M25 junction 10/A3 Wisley interchange TR010030 9.5 DCO Application Errata Schedule

9.5 DCO APPLICATION ERRATA SCHEDULE

Regulation Number:	Regulation 5(2)(q)
Planning Inspectorate Scheme Reference	TR010030
Additional Submission Reference	TR010030/AS-021 (2)
Author:	M25 junction 10/A3 Wisley interchange project team, Highways England and Atkins

SHEET **4** OF 31

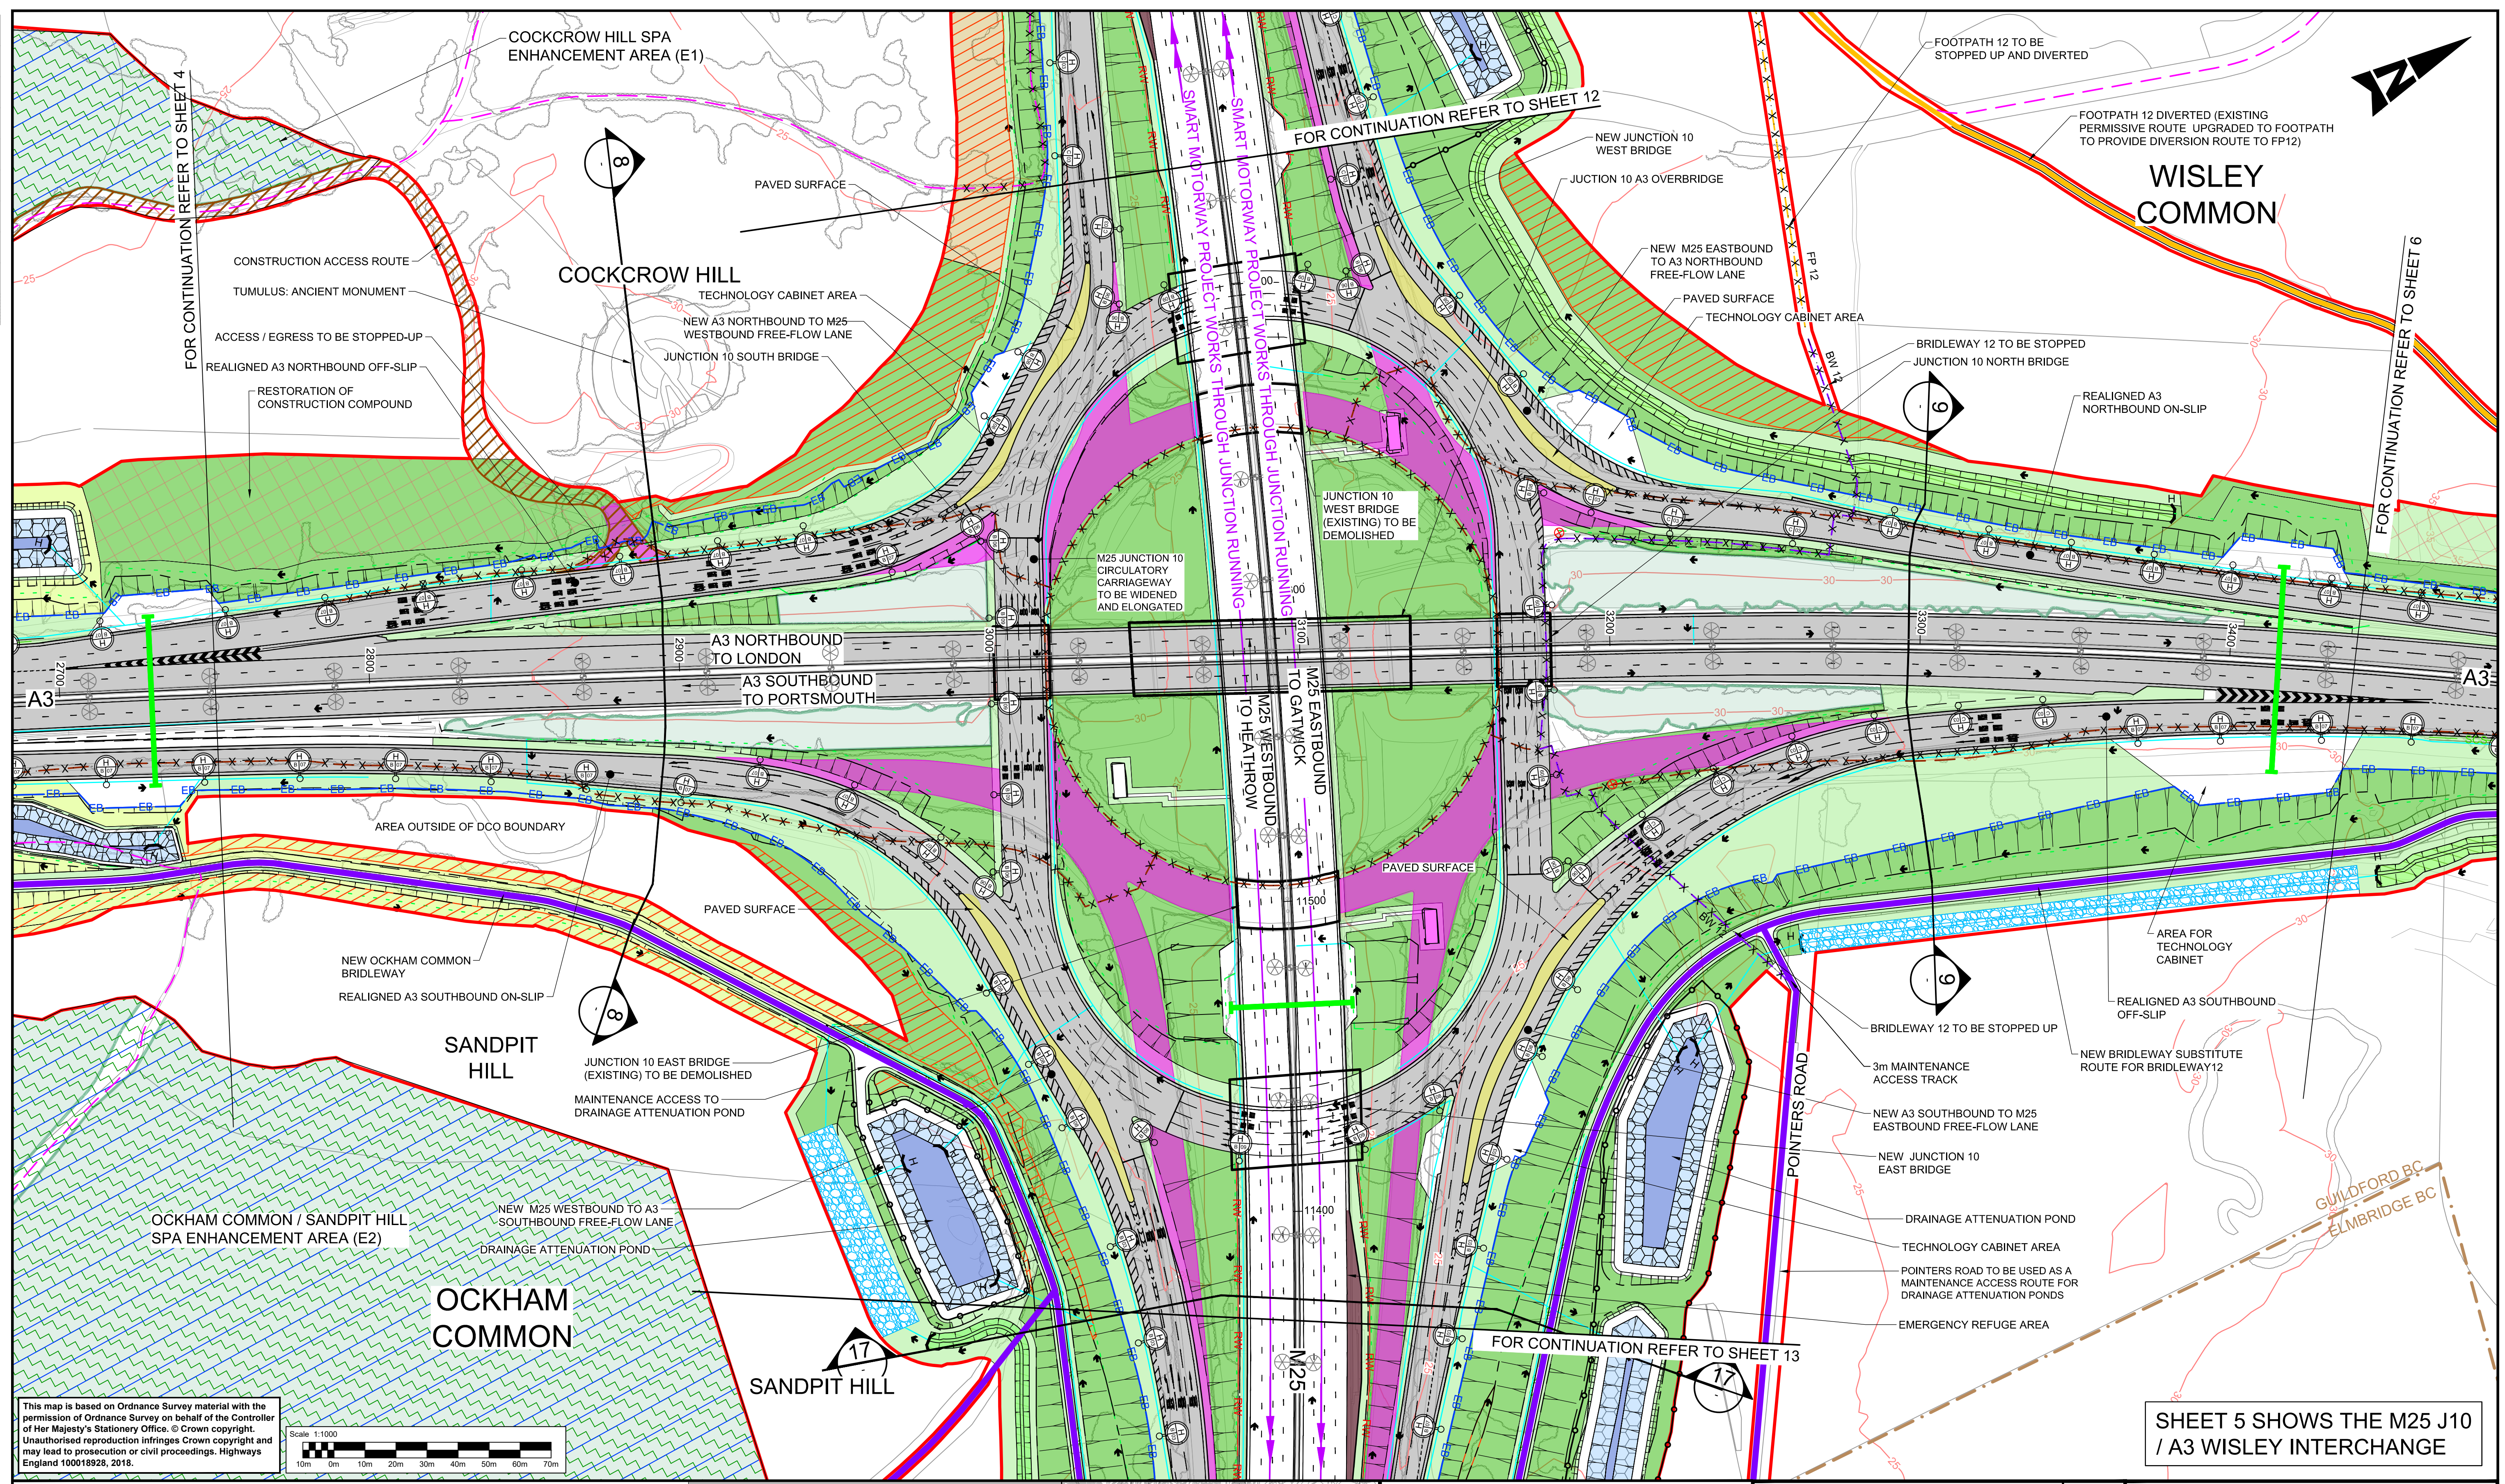
APP-012	2.8 Scheme Layout Plans	Sheet 4 of 31	The label reading "Existing access to Ockham Common car	Remove label

PINS Application Document Reference	Document name:	Section	Nature of Erratum and explanation	Correction
			The correct figure is 27%.	
Deadline 1				
APP-012	2.8 Scheme Layout Plans (Sheets 1-10 of 31)	Sheet 4 of 31	The label reading "Cockrow Hill SPA Enhancement Area E7" is incorrect.	Change text to "Cockrow Hill SPA Enhancement Area E1"
APP-012	2.8 Scheme Layout Plans (Sheets 1-10 of 31)	Sheet 5 of 31	The label reading "Cockrow Hill SPA Enhancement Area E7" is incorrect.	Change text to "Cockrow Hill SPA Enhancement Area E1"
APP-013	2.8 Scheme Layout Plans (Sheets 11-31 of 31)	Sheet 21 of 31	The label reading "Cockrow Hill SPA Enhancement Area E7" is incorrect.	Change text to "Cockrow Hill SPA Enhancement Area E1"
APP-029	5.1 Consultation Report: Annex C - Statement of Community Consultation	Table of Contents	The Table of Contents incorrectly refers to the document as "Appendix C. Statement of Community Consultation."	Change the text to "Annex C. Statement of Community Consultation."
